From:
Sent: 22 July 2026 17:27
To: Katie Chew
Cc: DC Admin
Subject: Planning Application 2026/91657 - Comment - Topography, Reversed Driveway Gradient and Turning Area

Part outline site plan (1:500)

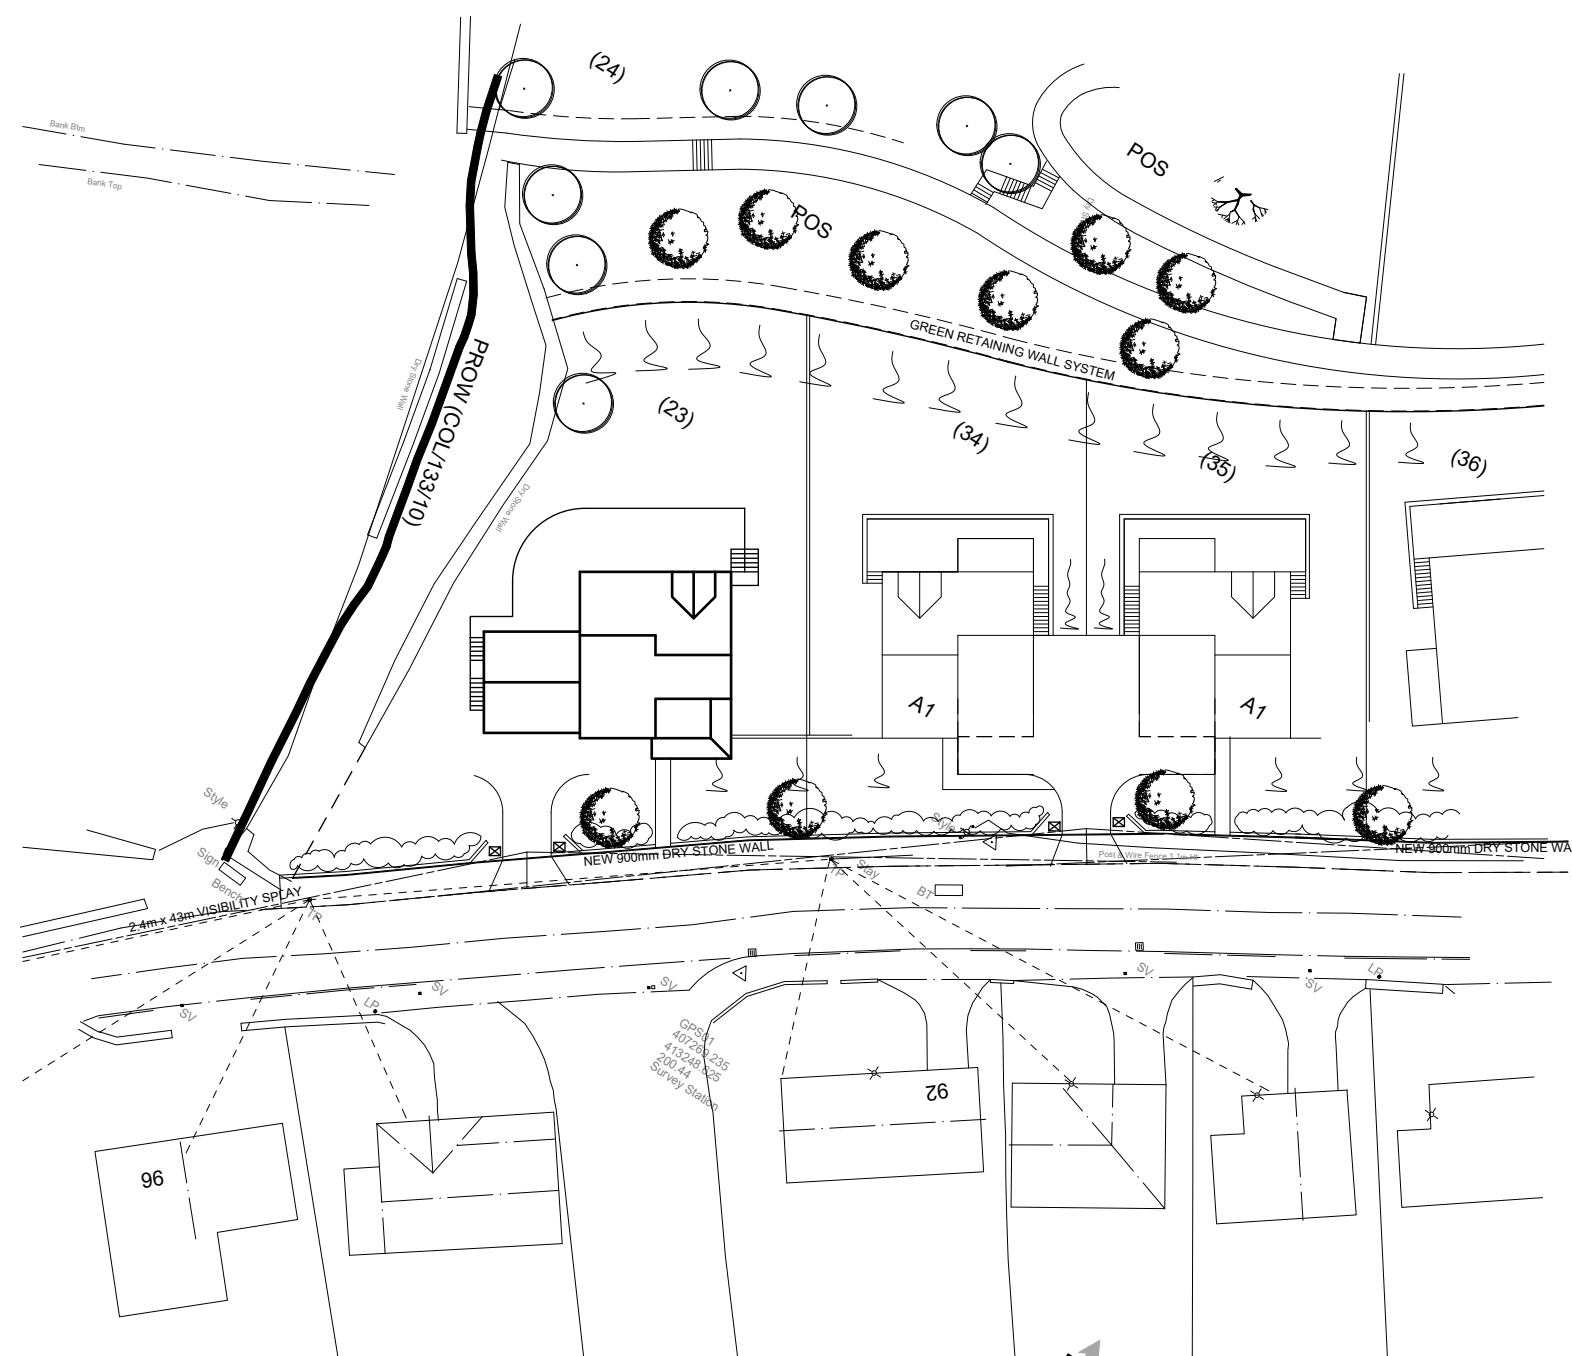
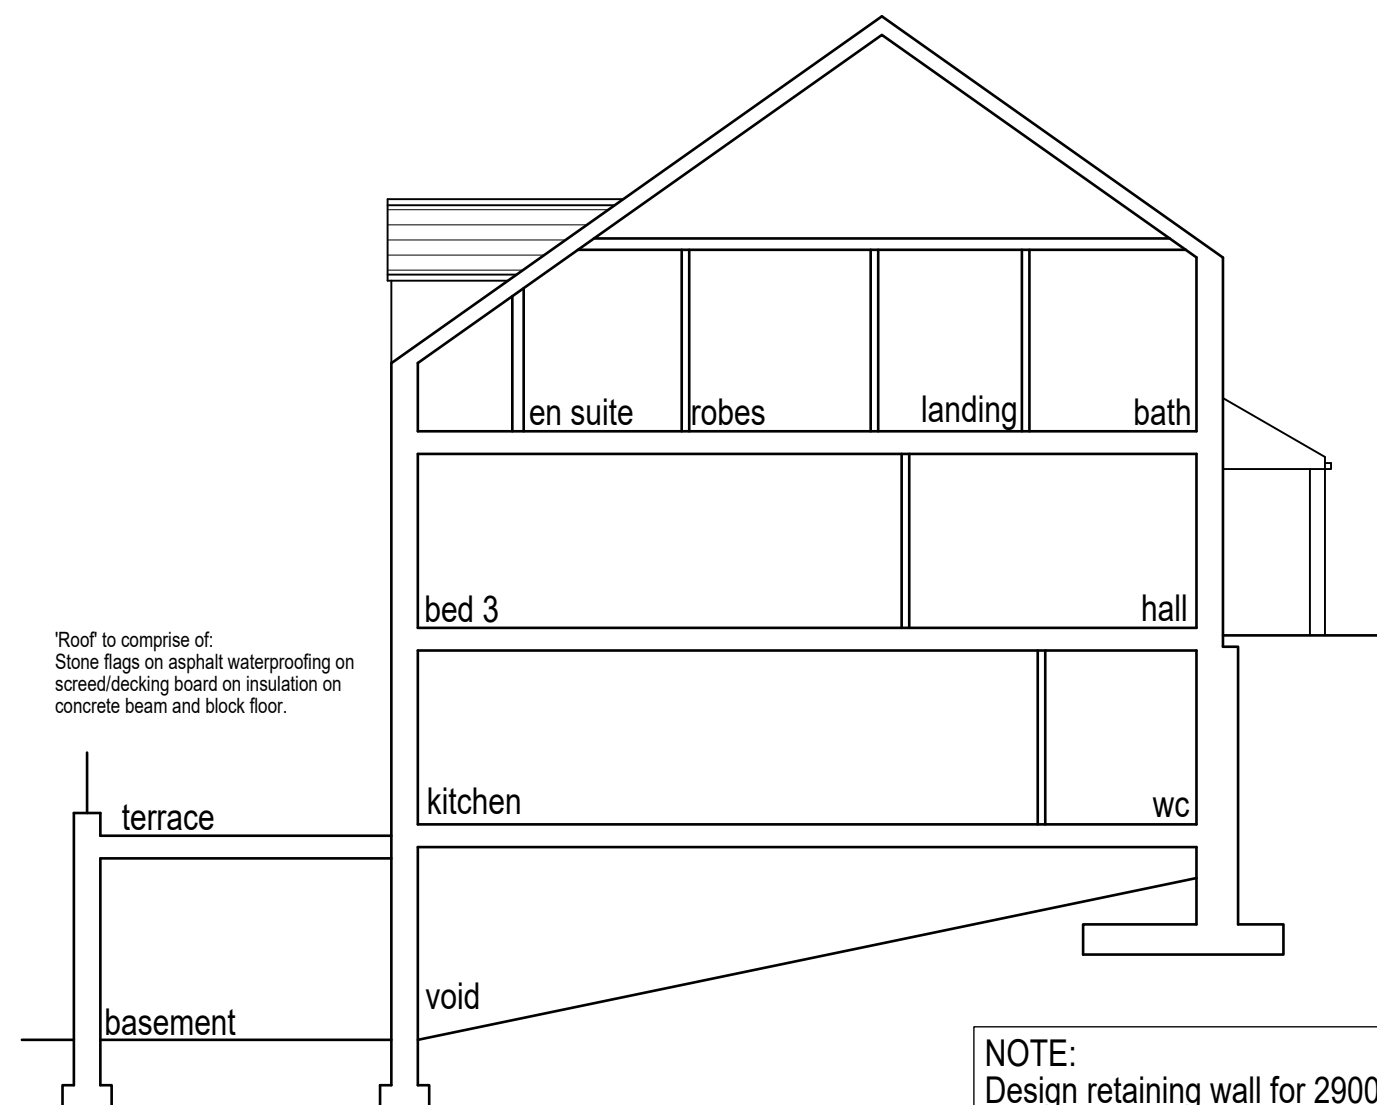
The scheme previously considered by the Planning Sub-Committee showed the driveway falling from the pavement towards a single garage. The apparent as-built level reverses that arrangement: vehicles would now have to climb from Lingards Road towards an elevated garage and turning area.

The current proposal is also for a double garage, creating capacity for more vehicles and more frequent manoeuvring than the single-garage arrangement previously assessed. The driveway includes a substantial turning area, so it cannot be assessed by applying one average gradient. The Council must consider the gradients, crossfalls, vehicle turning movements and drainage across the whole paved area.

Before application 2026/91657 is determined, the Council should require verified as-built levels, detailed grading and drainage plans for the driveway and turning area, vehicle tracking, and a fresh assessment of headlight sweep towards No. 92, traffic on Lingards Road and the public right of way.
